GREY HOUSE PRECINCT,  
PYMBLE LADIES' COLLEGE

SSD-17424905

Architectural Design Report  
Addendum

05. 04. 22

SHADOW DIAGRAMS -
SHEET 4

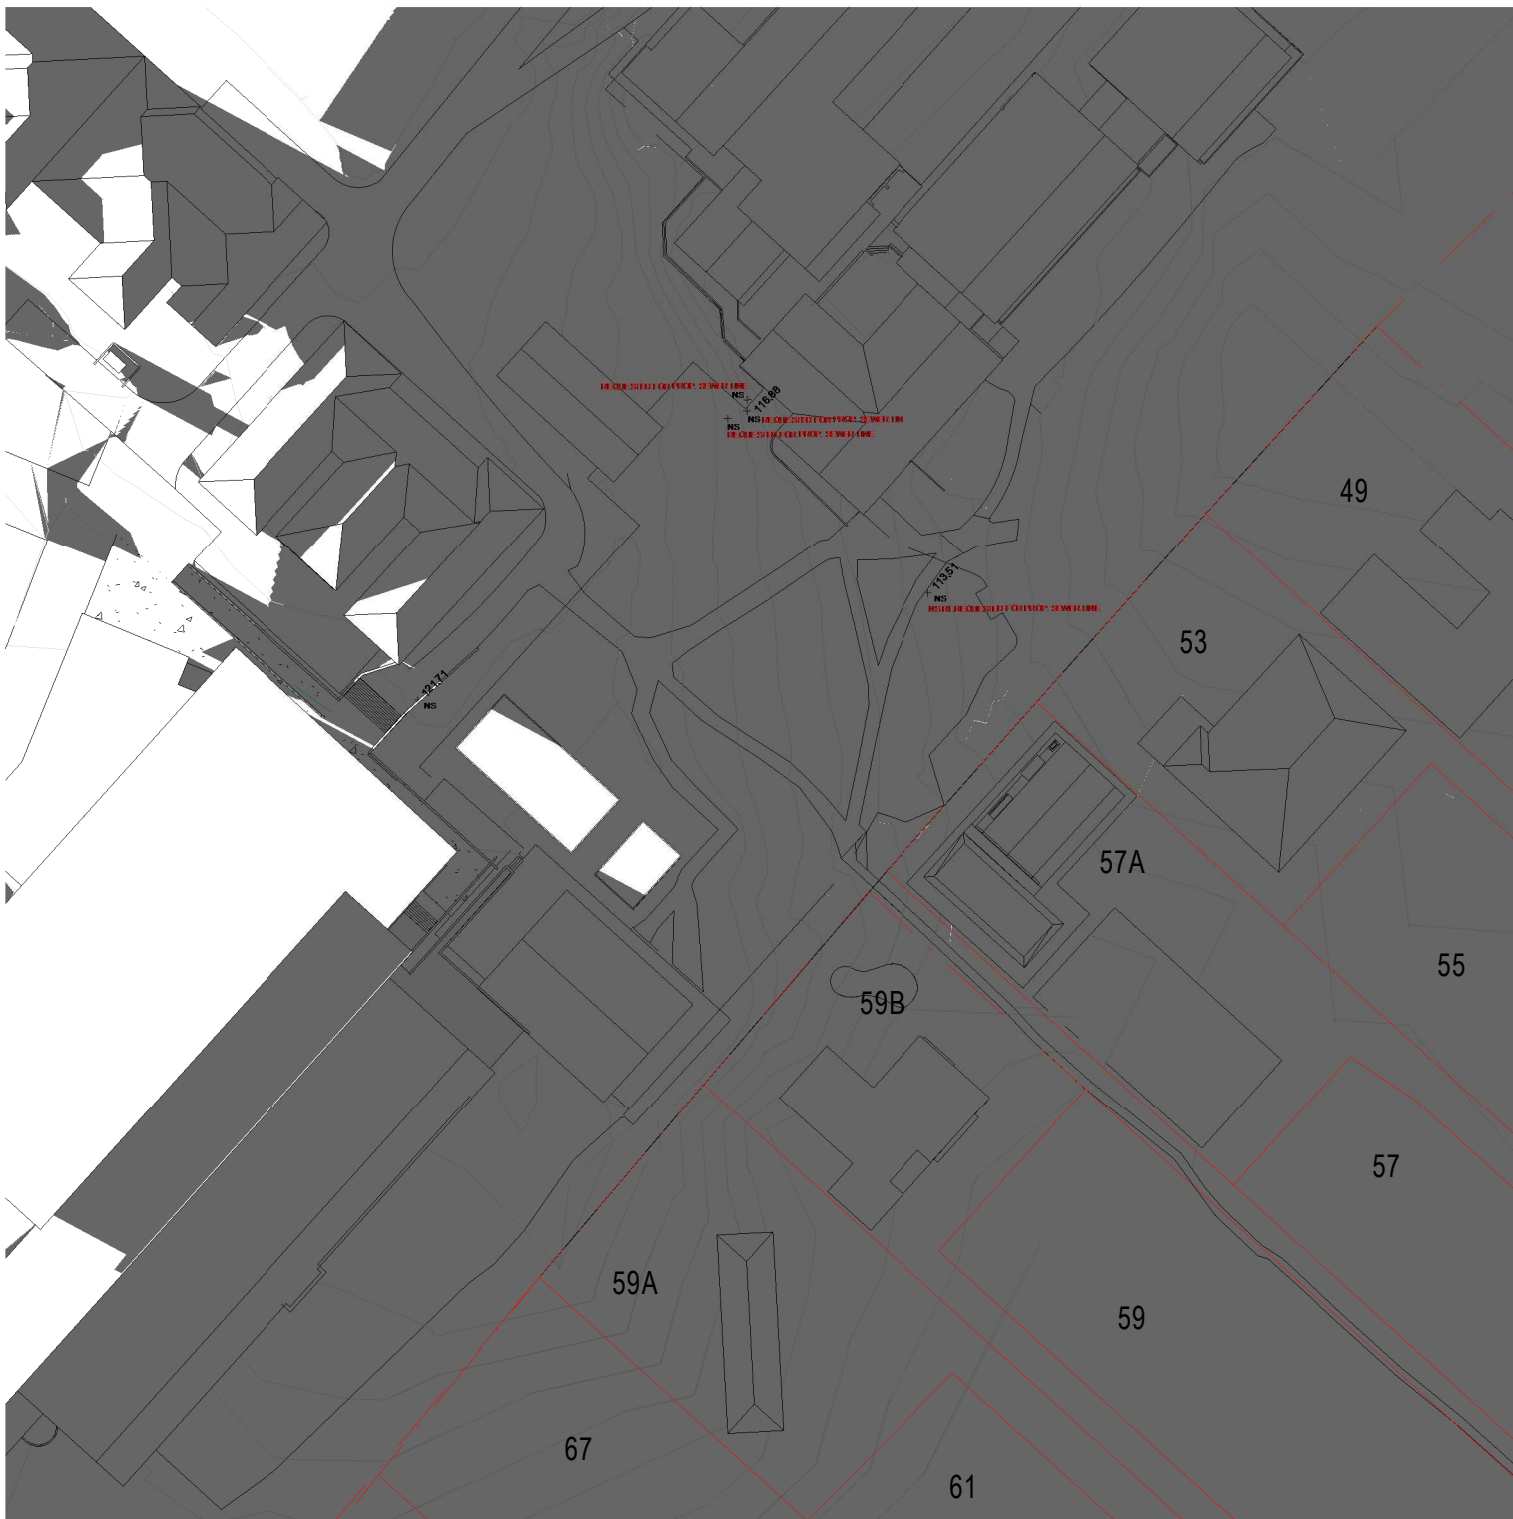
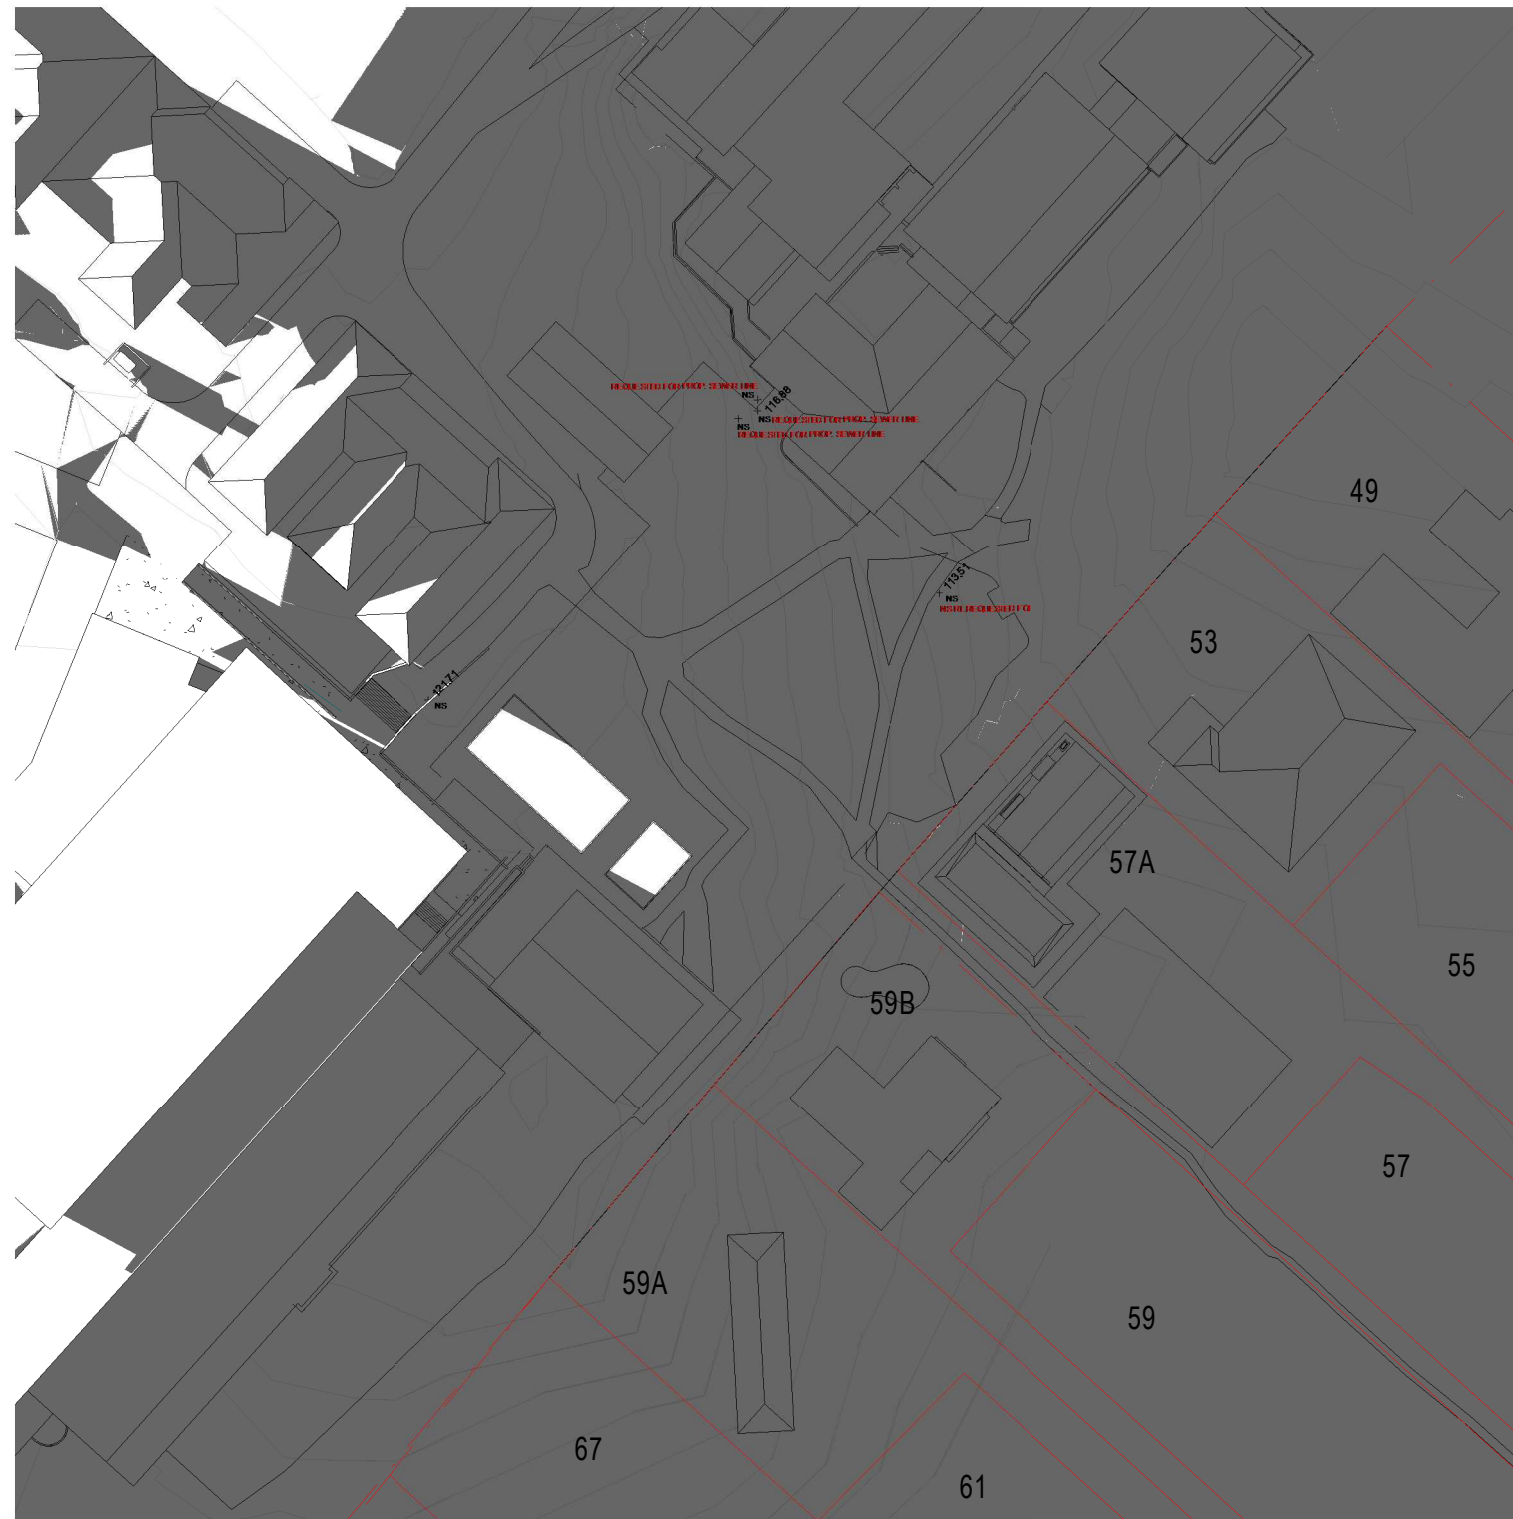
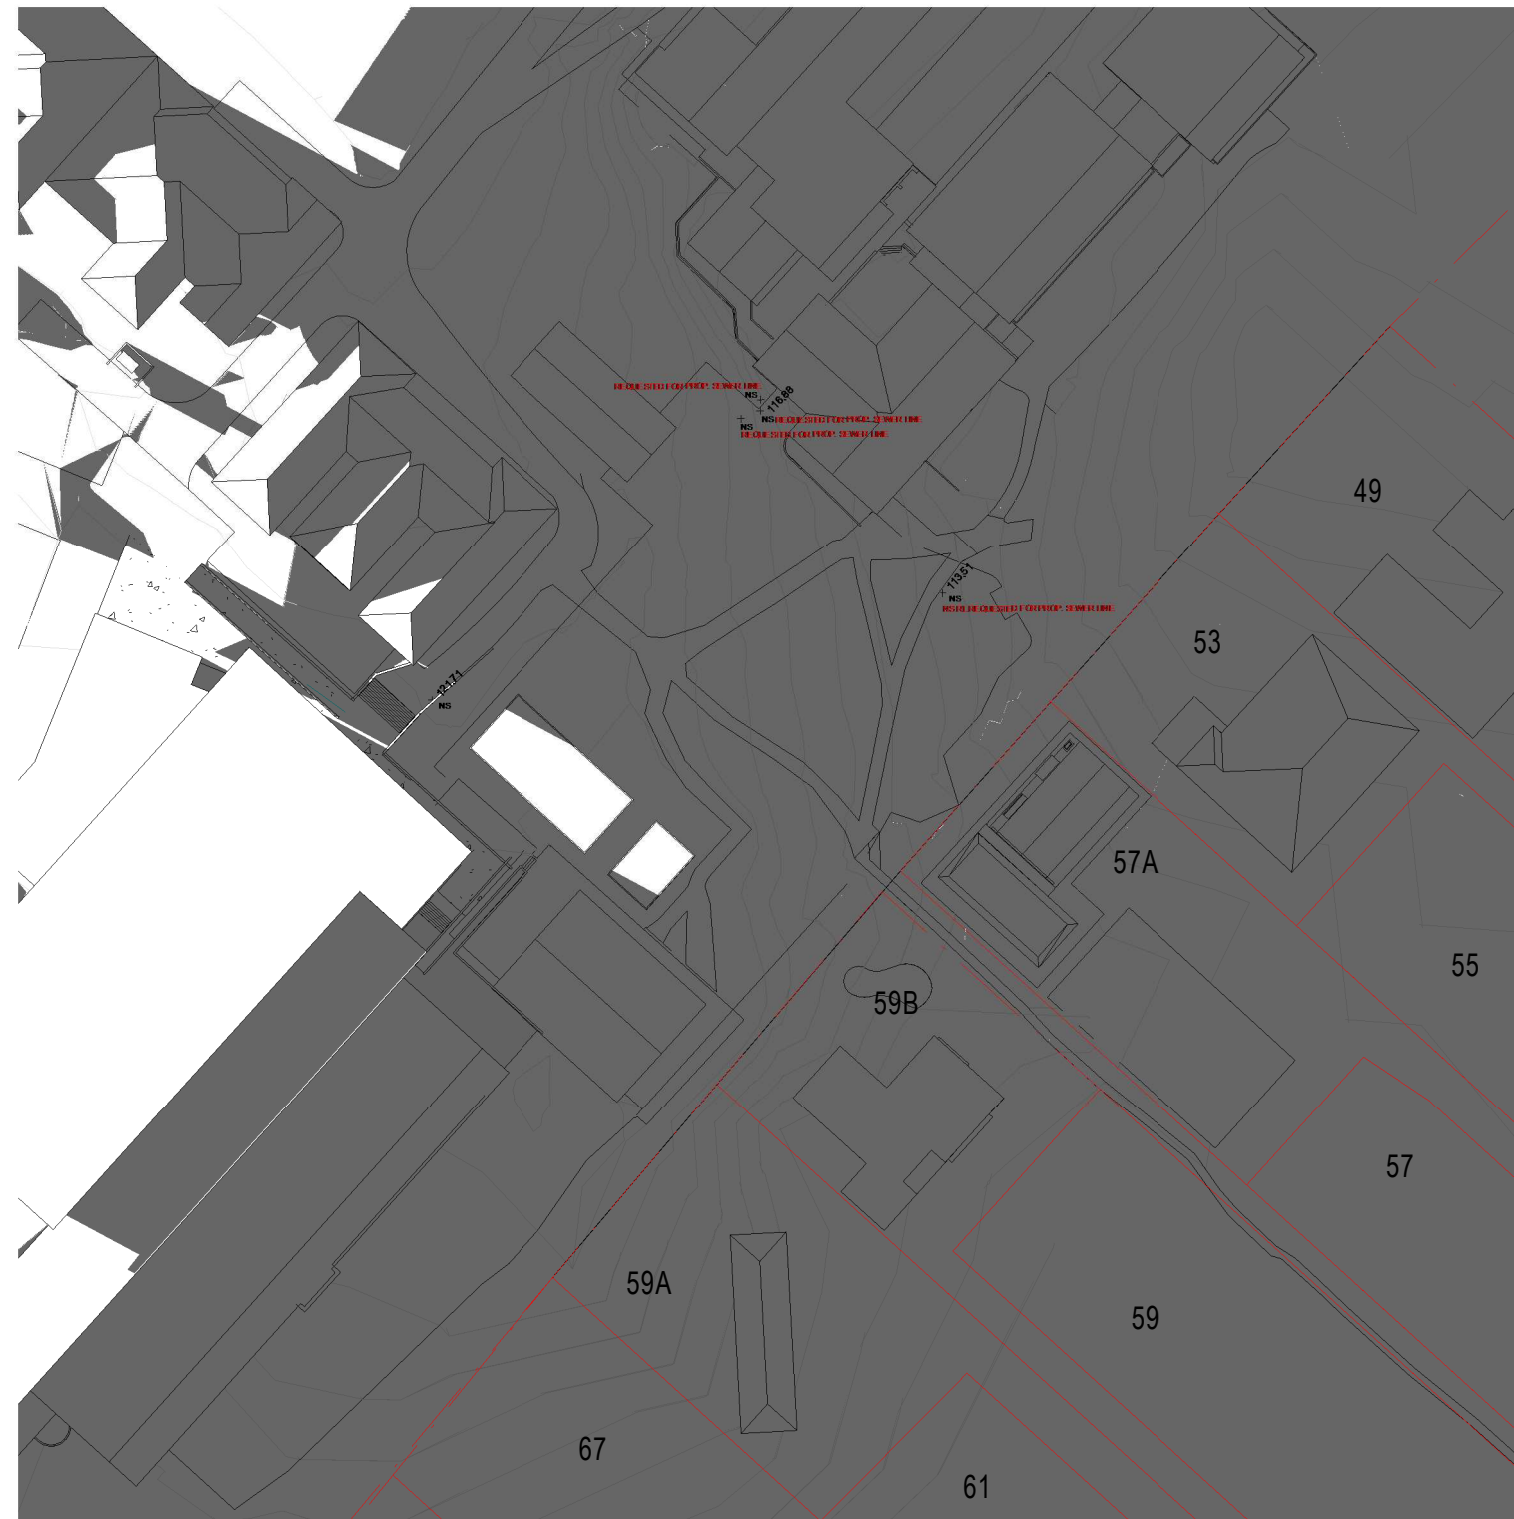
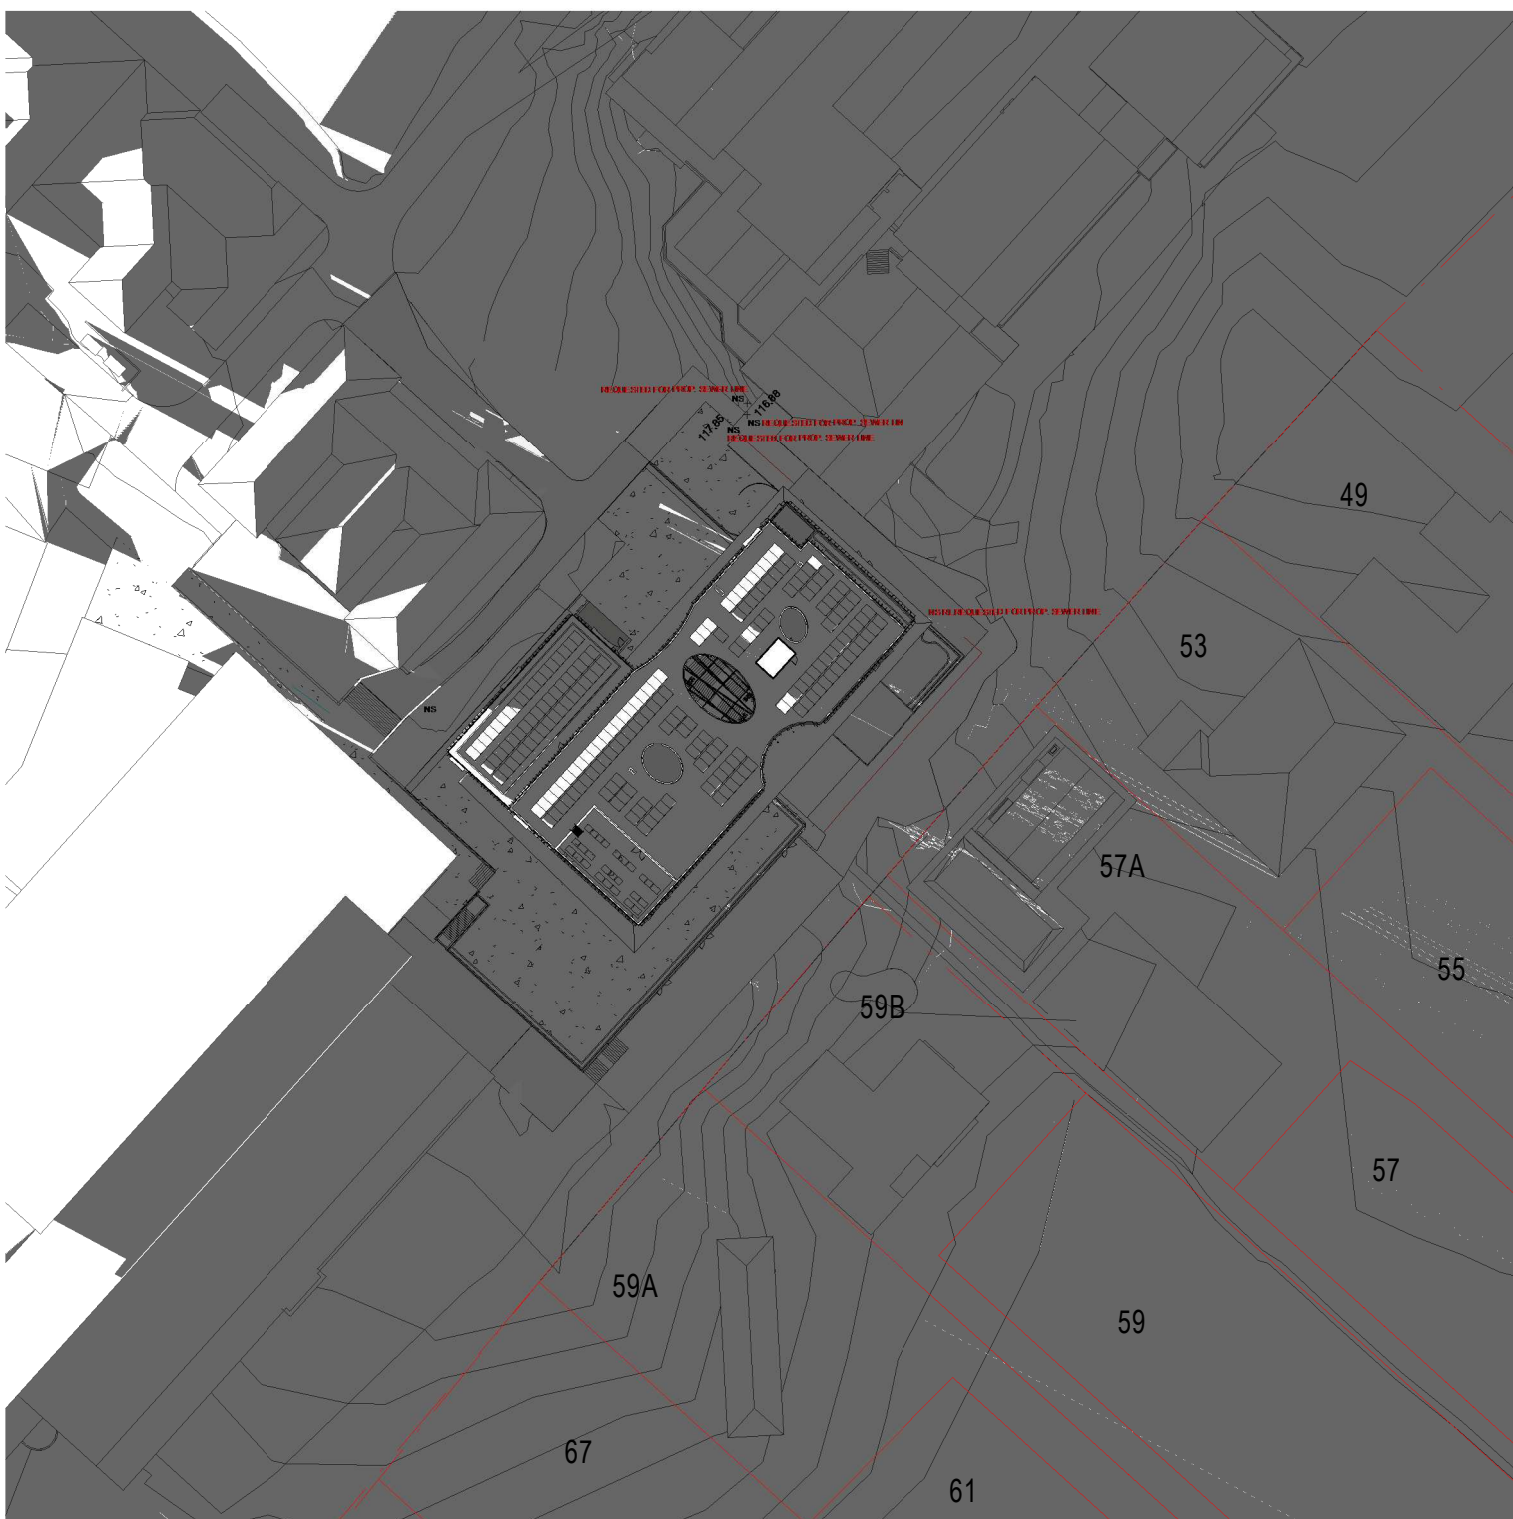
11. Clarify the impact of the proposal on the solar access of the adjoining properties, as this has not been clearly demonstrated. Provide existing and proposed diagrams identifying the quantum of solar access to the living area glazing and the principal private open space of affected properties to demonstrate if a reasonable level of solar access will be maintained for the adjoining properties.

This report includes solar access analysis of the impact of the Grey House Precinct to the adjoining residential properties.
